68 Deering St., BP#2014-02509

remaining questions:

BATHROOM ELEVATION 1ST FLOOR

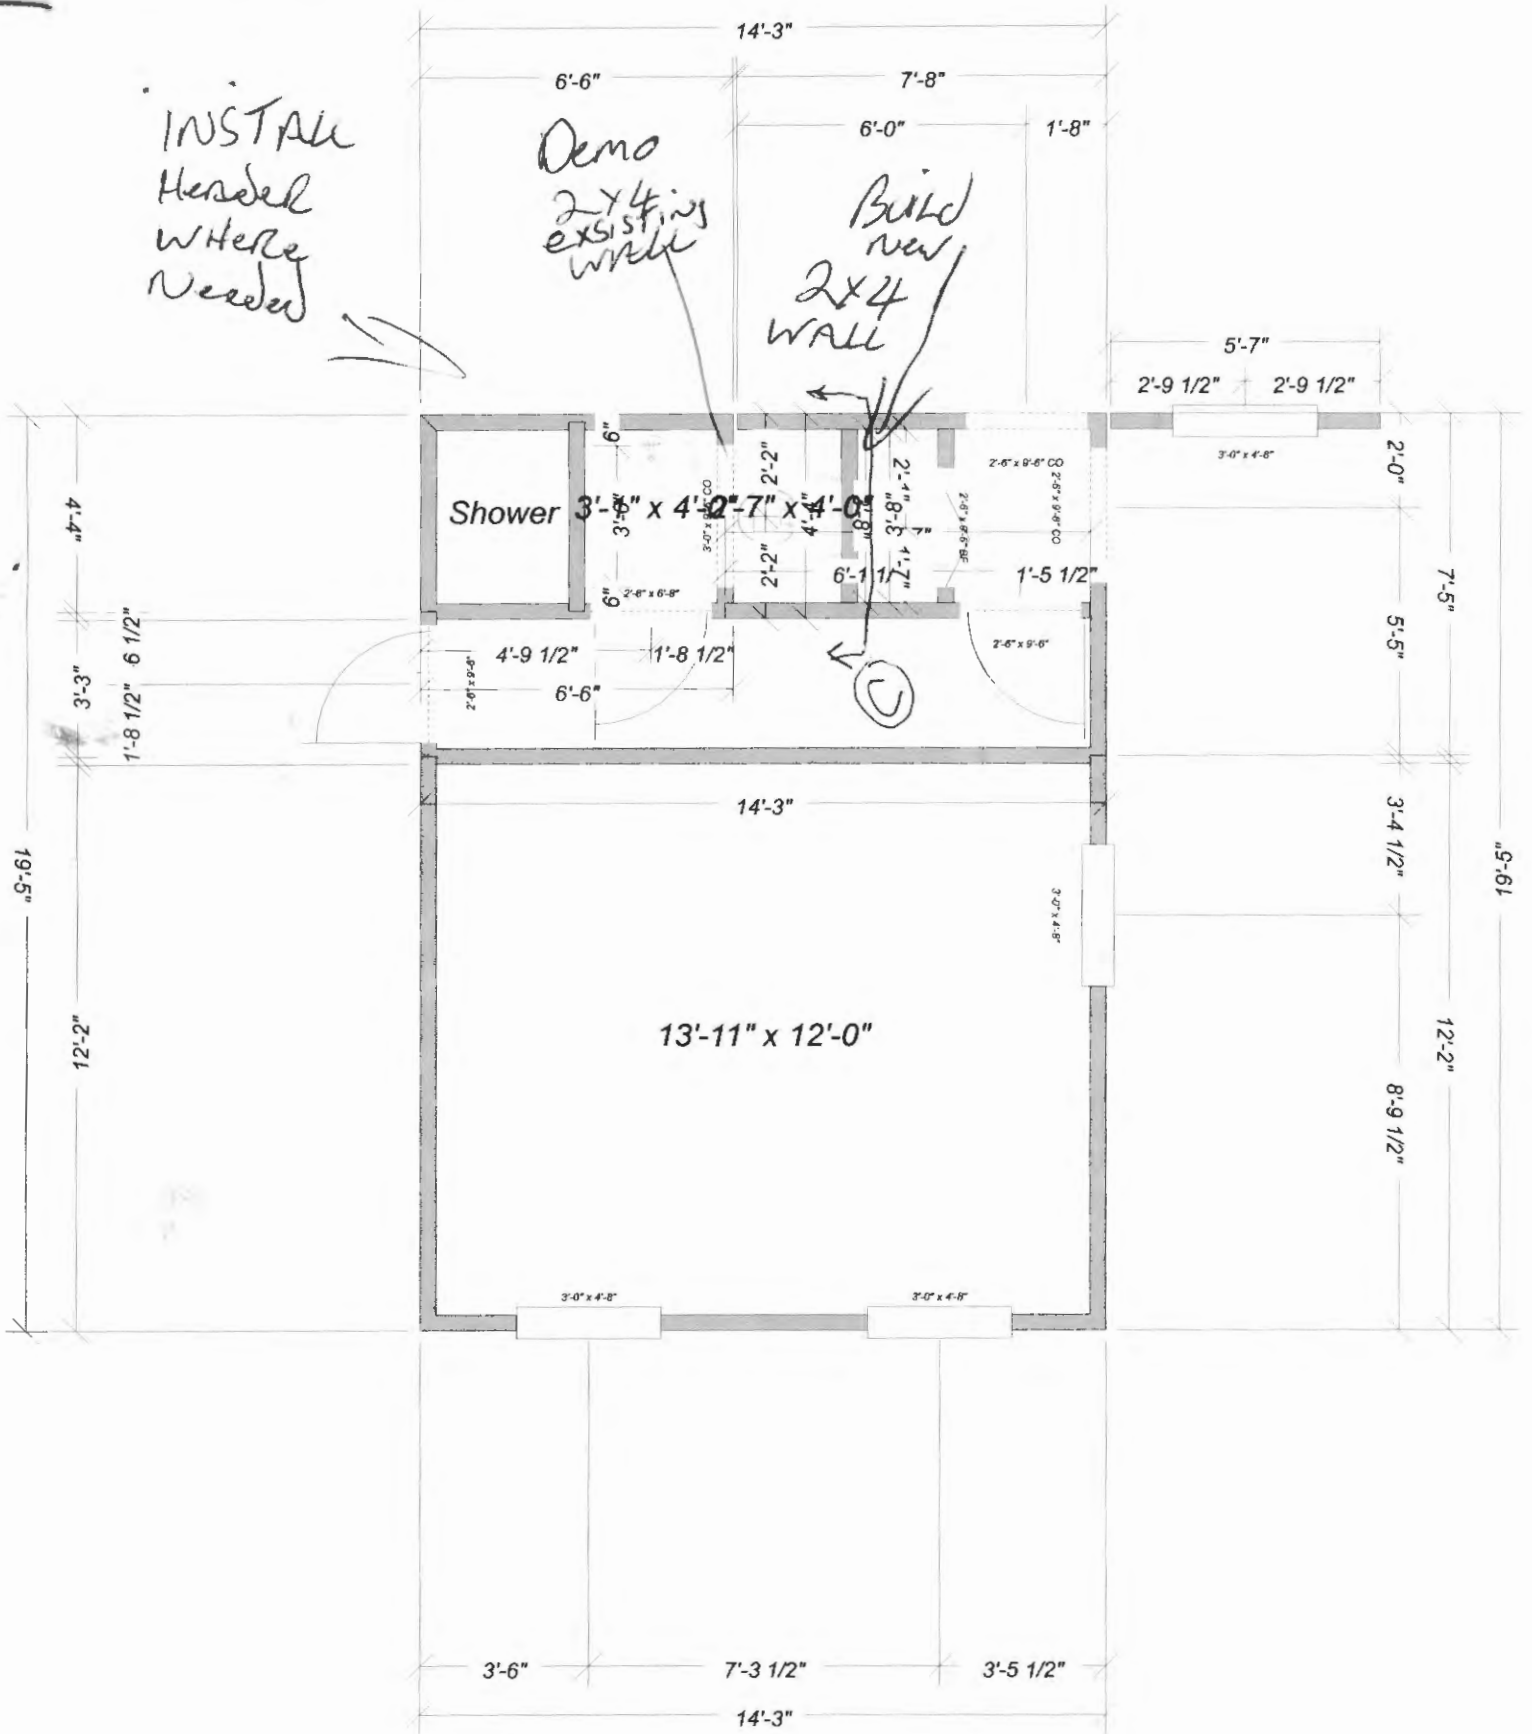
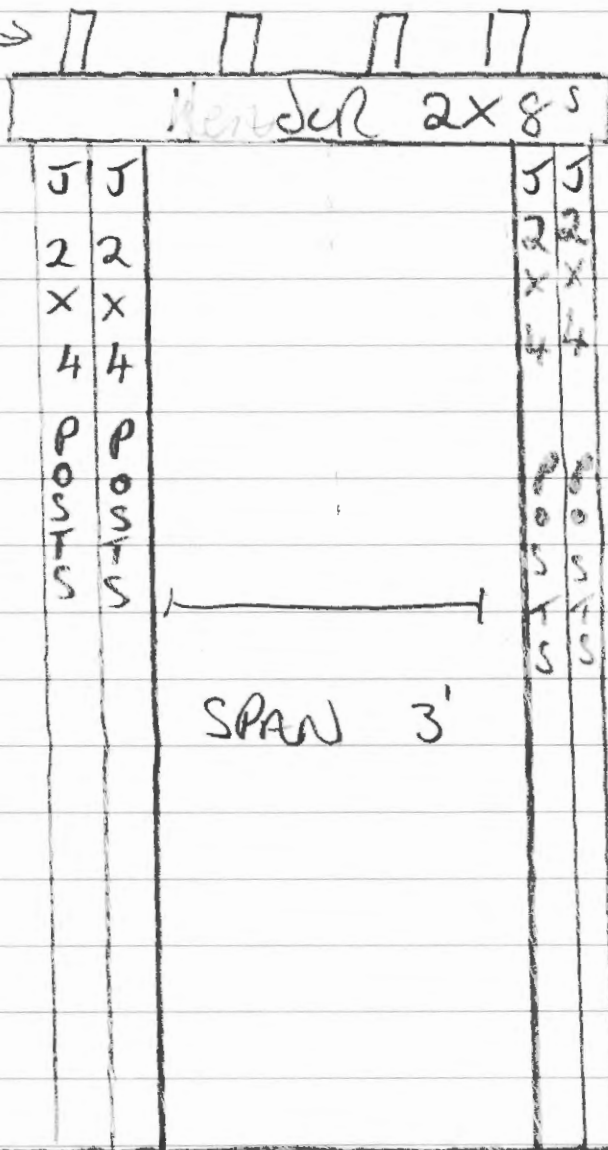
-Diagram of the load bearing path at all new Engineered beams,

including any new footings and columns in the basement

Steel I-beam for 40" span in bathroom to solid brick wall. I beam carries the upper load with force paths going into the brick supporting the beam. The beam is supported by 6" of brick on either side. Door header in the brick will either be a standard 4" I beam or back to back steel "c" channels. All steel is 1/4" thick

Only steel I-beam. On the first floor, only the wall in the bathroom is weight bearing.

FIRST FLOOR
68 DEERING ST

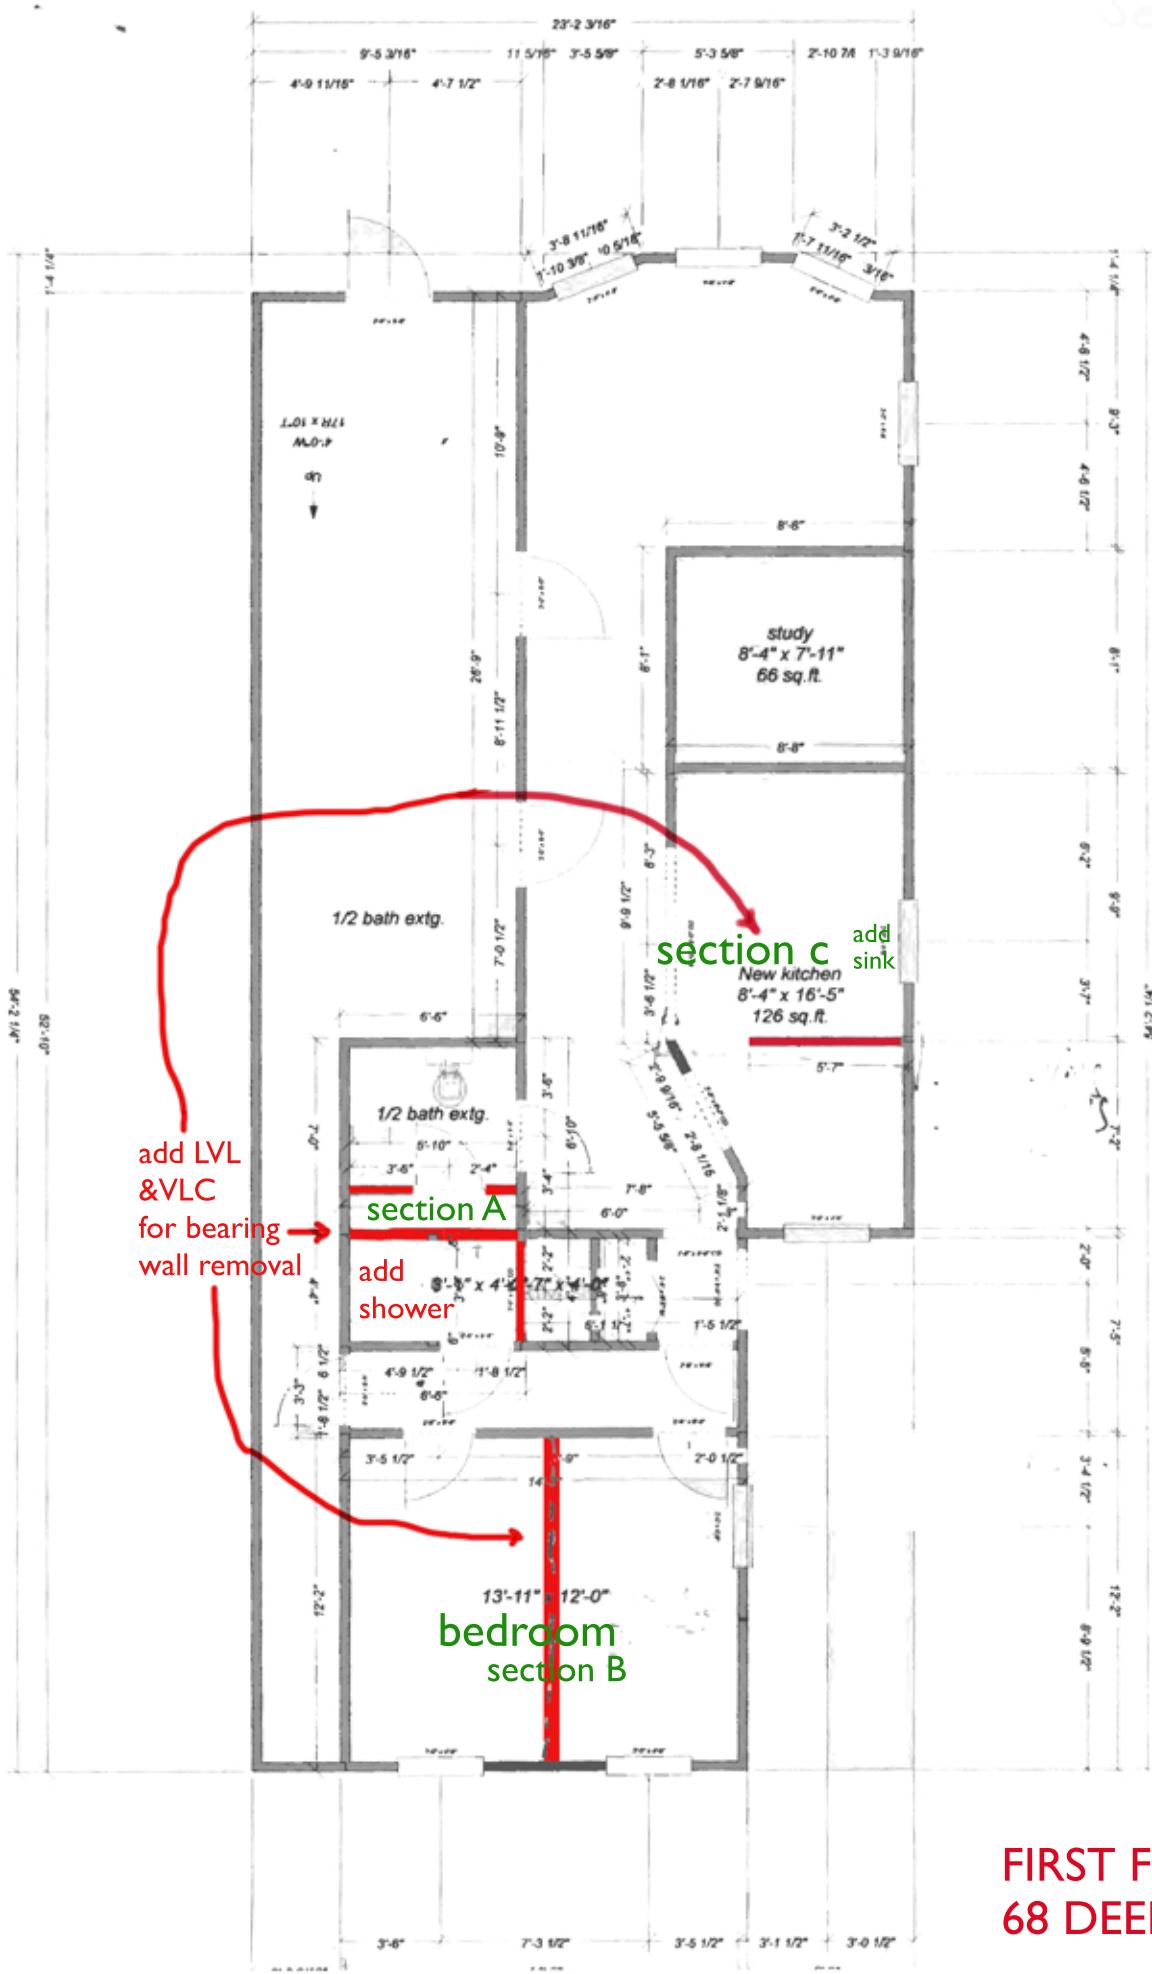
The original floor plan with wall removal and LVL shows 3 locations for beams, bathroom, kitchen and bedroom. Please clarify this and the load bearing support of these beams.

After further inspection, it is evident that the walls in the kitchen, bedroom are not load bearing. These will not require header supports to remove.

The kitchen is moved to the interior wall to be closer to the existing plumbing.
